# CITY OF ALBUQUERQUE

PLANNING DEPARTMENT – Development Review Services

July 24, 2014

**RE: Eagle Crest Subdivision  
Drainage Report and Grading and Drainage Plan  
Engineer's Stamp Date 7-3-14 (File: C18D064B)**

DRAWING TITLE:
GRADING AND DRAINAGE PLAN

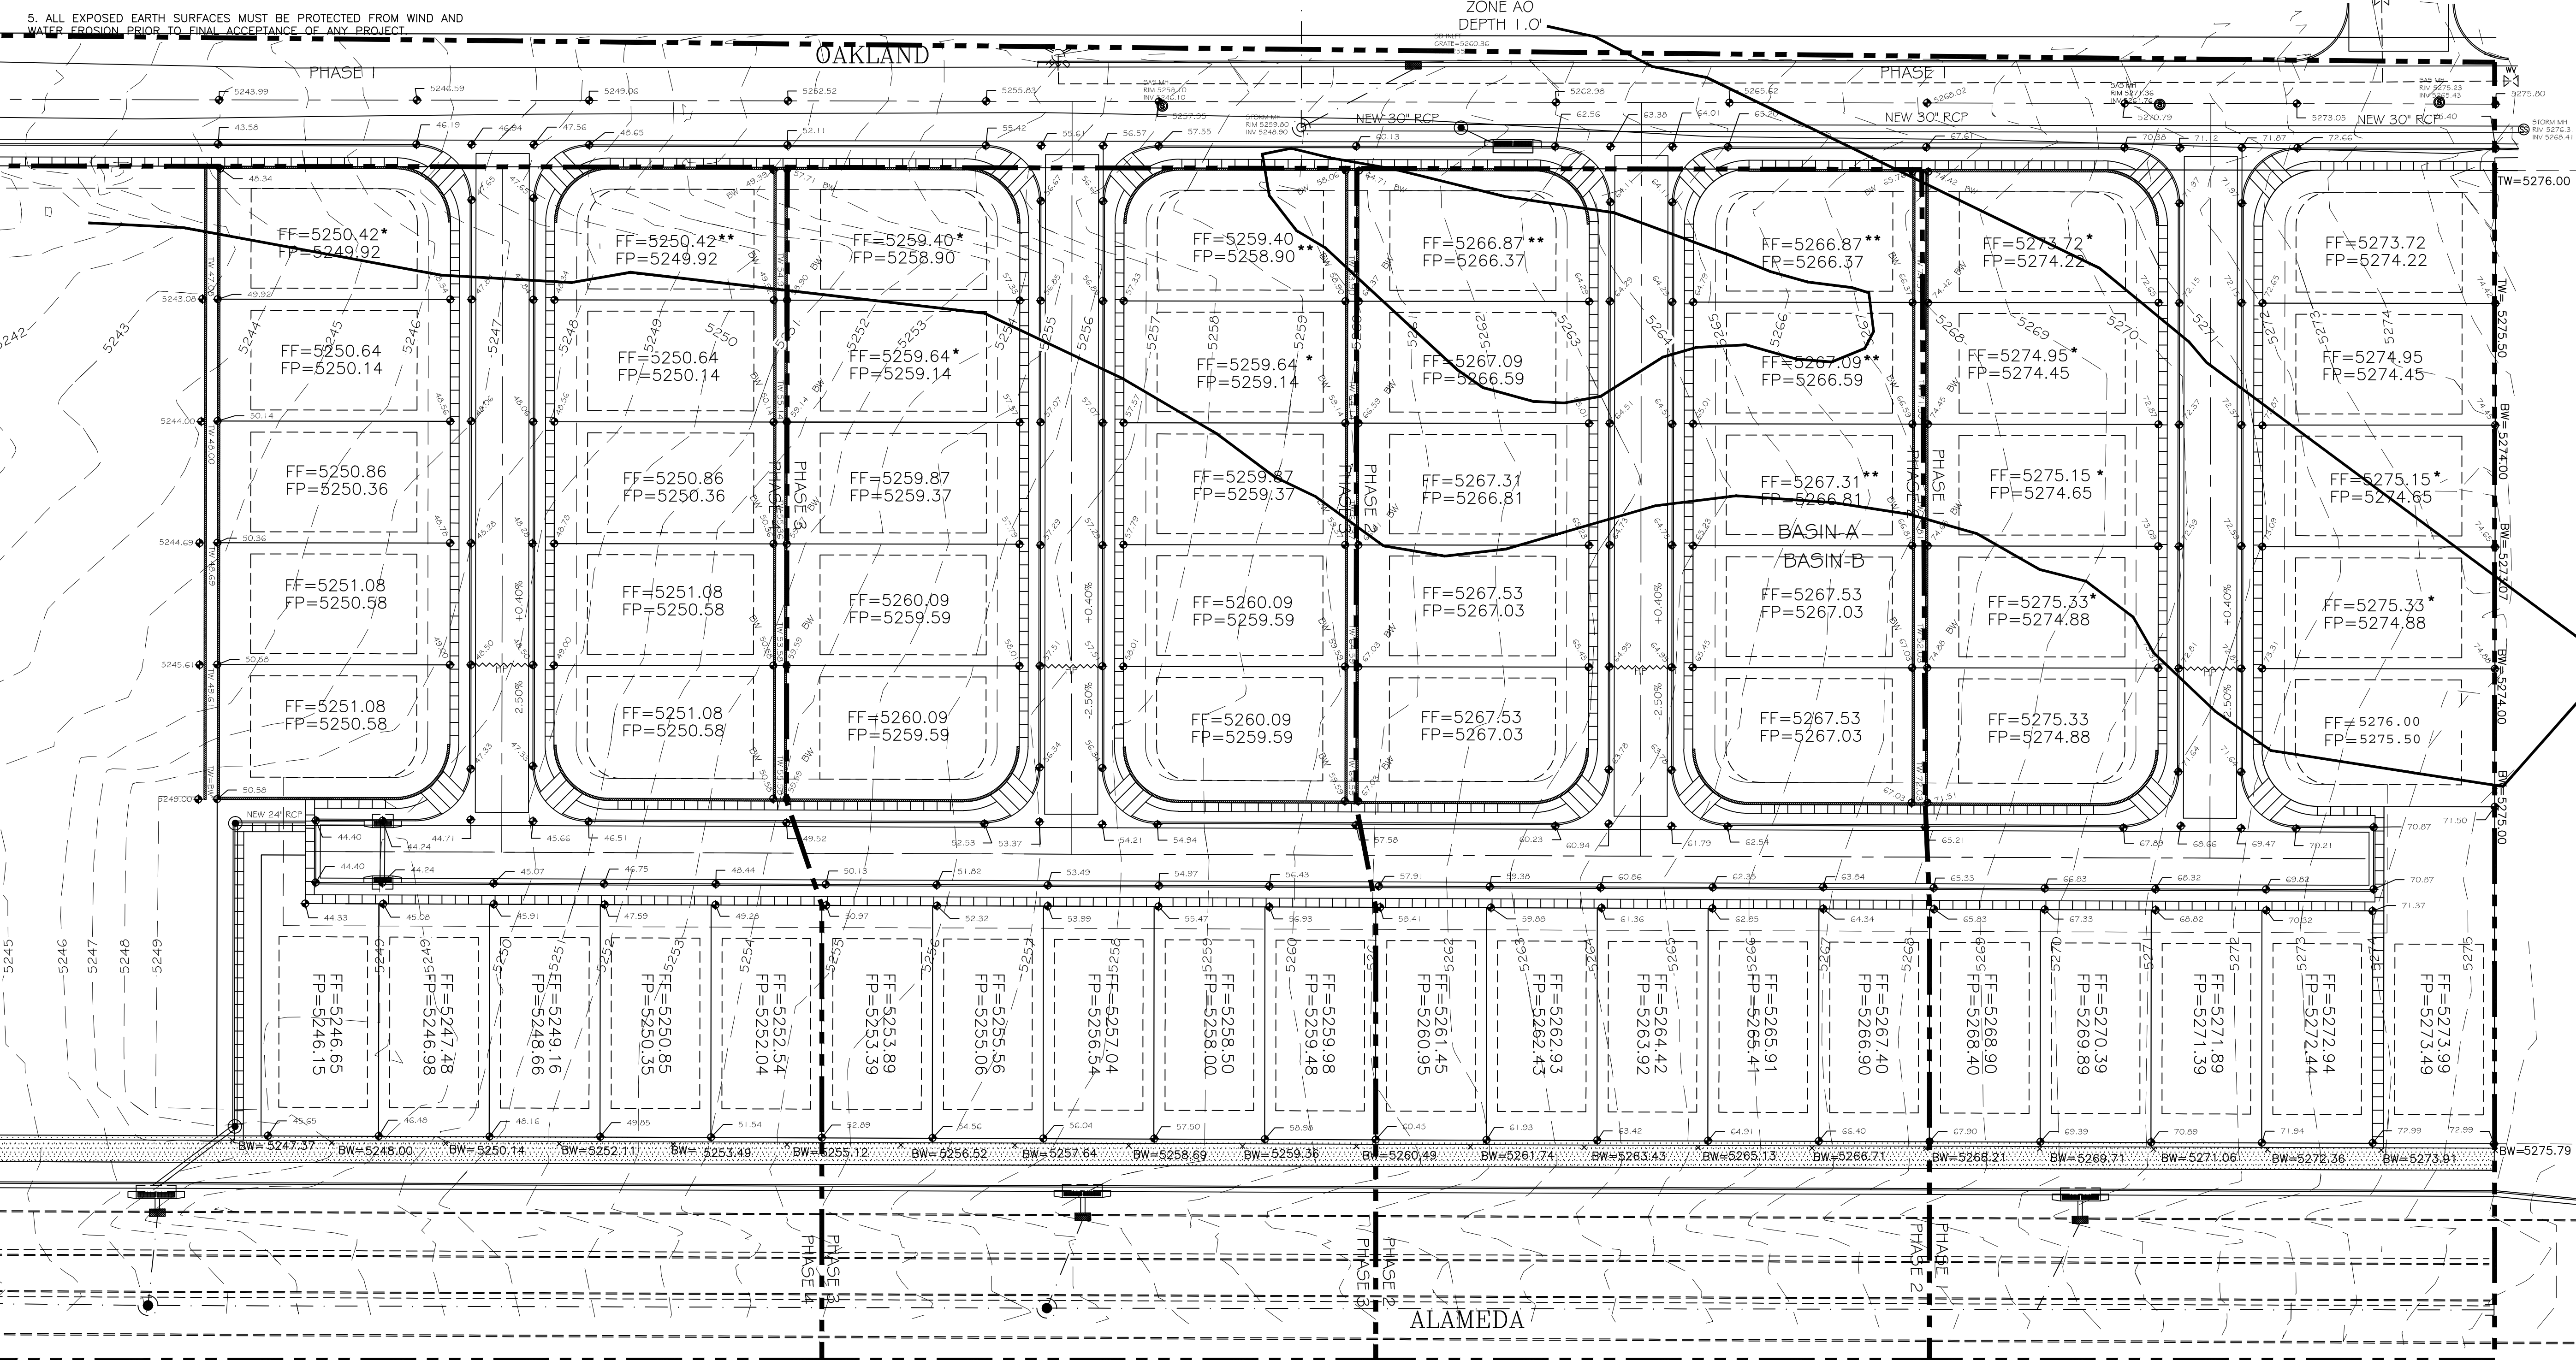
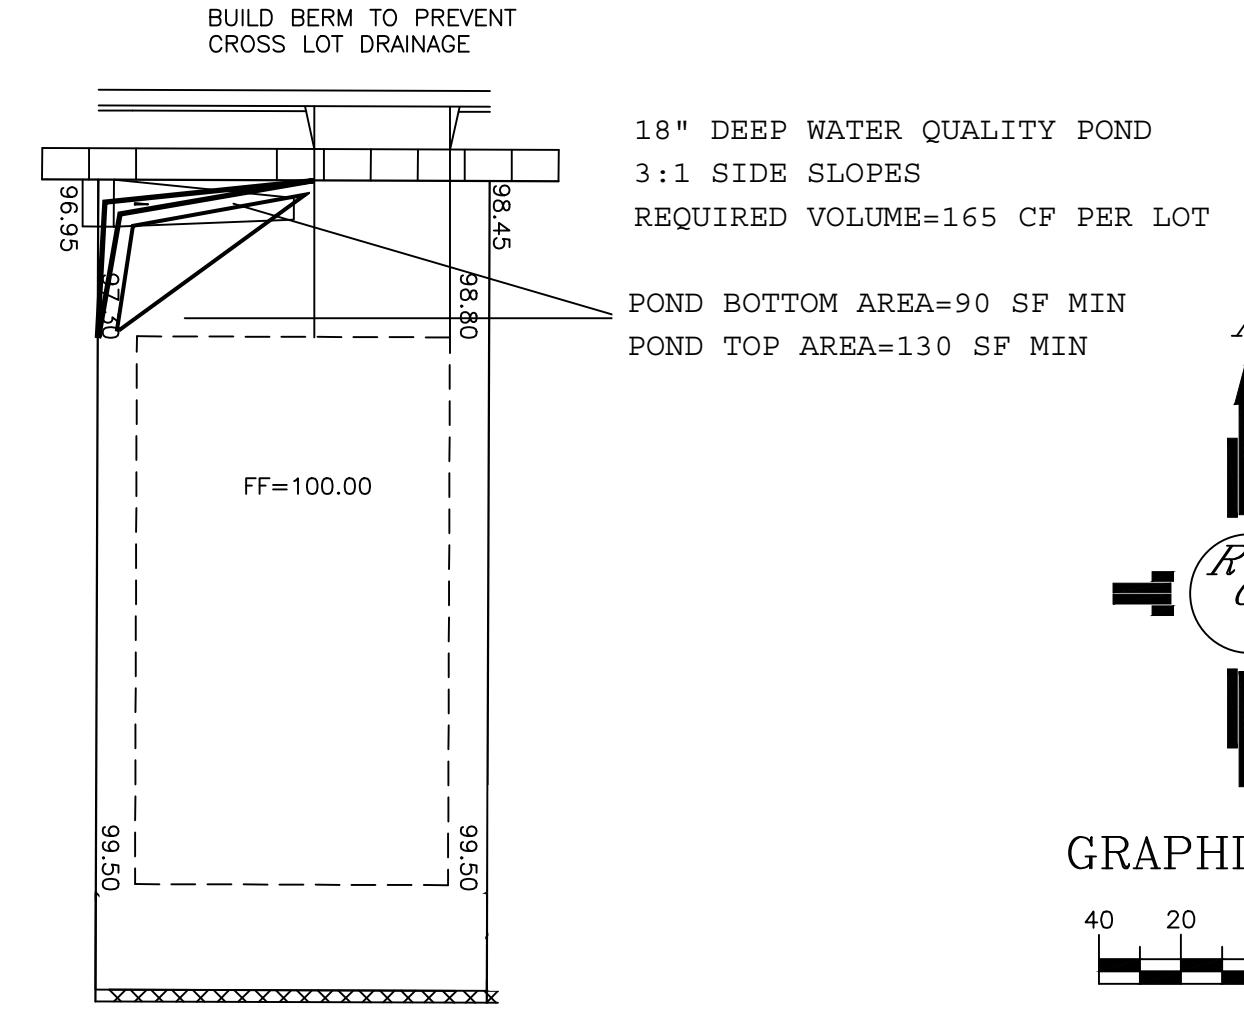
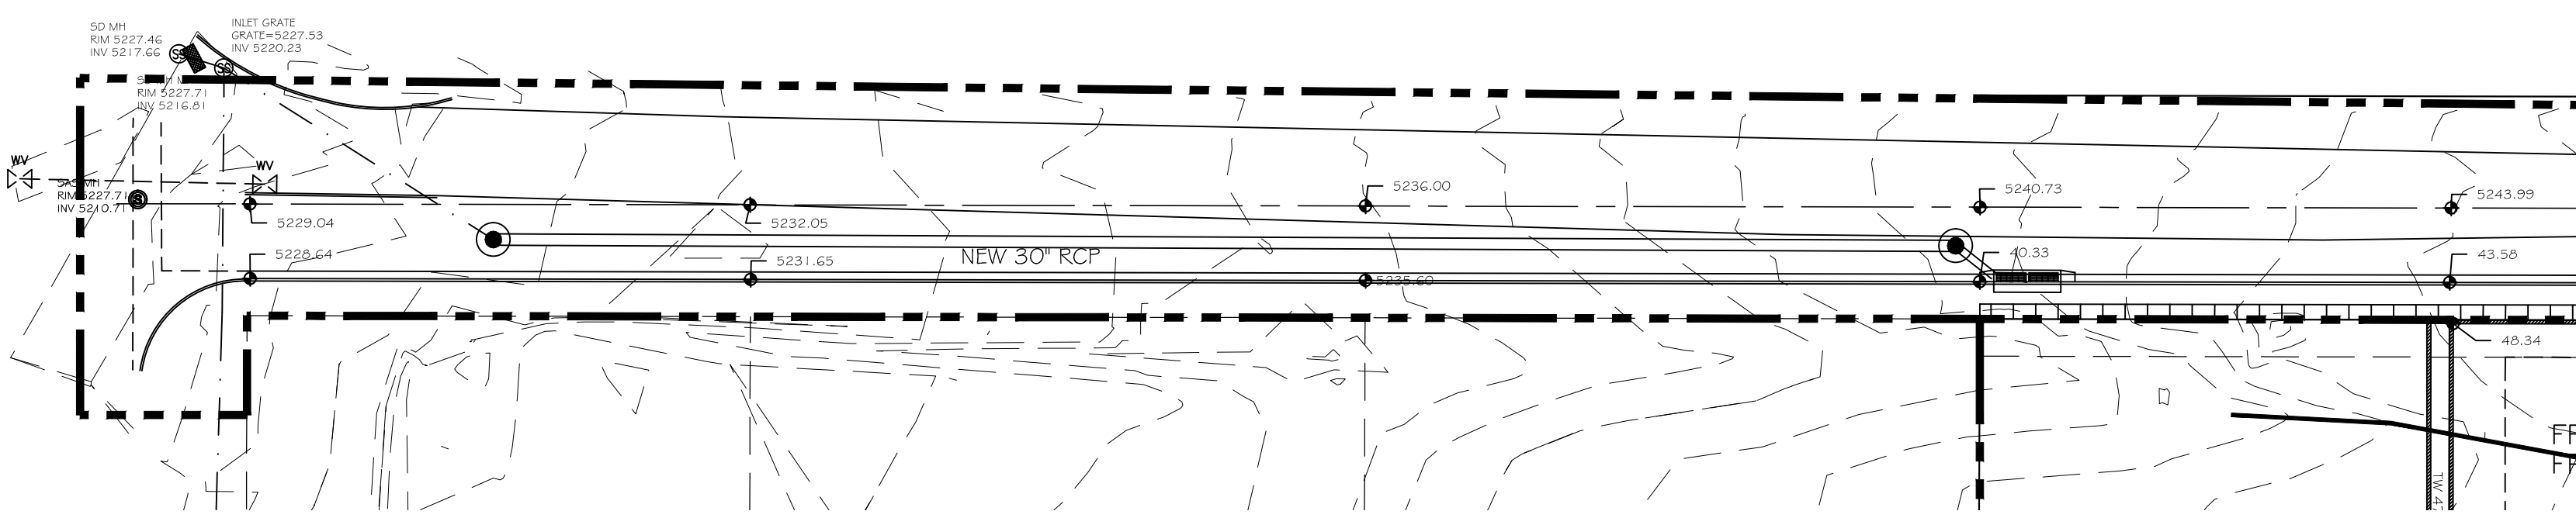
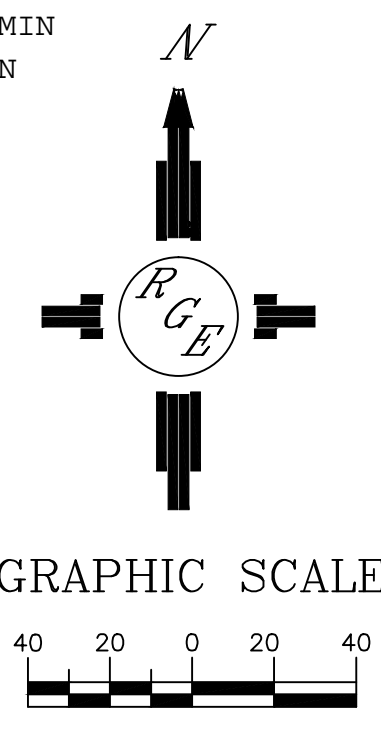
1. Since the proposed subdivision is partially in a Special Flood Hazard Area (AO with 1 ft. depth) an application for a LOMR is in order. However, until such time that the LOMR is approved, the City cannot issue building permits within a flood zone. Therefore, in the interest of time, it may be beneficial to raise the finished pads above the Base Flood Elevation and apply for a LOMR-F. The finished pads would have to be 1' above the highest contour elevation that crosses the lot.
2. Since this project is to be phased, a scheme to handle drainage must be determined for all the interim conditions, and also the final condition.
3. Ponding used for the management of the "first flush" should be only on the front yard as backyards are often landscaped and modified substantially.
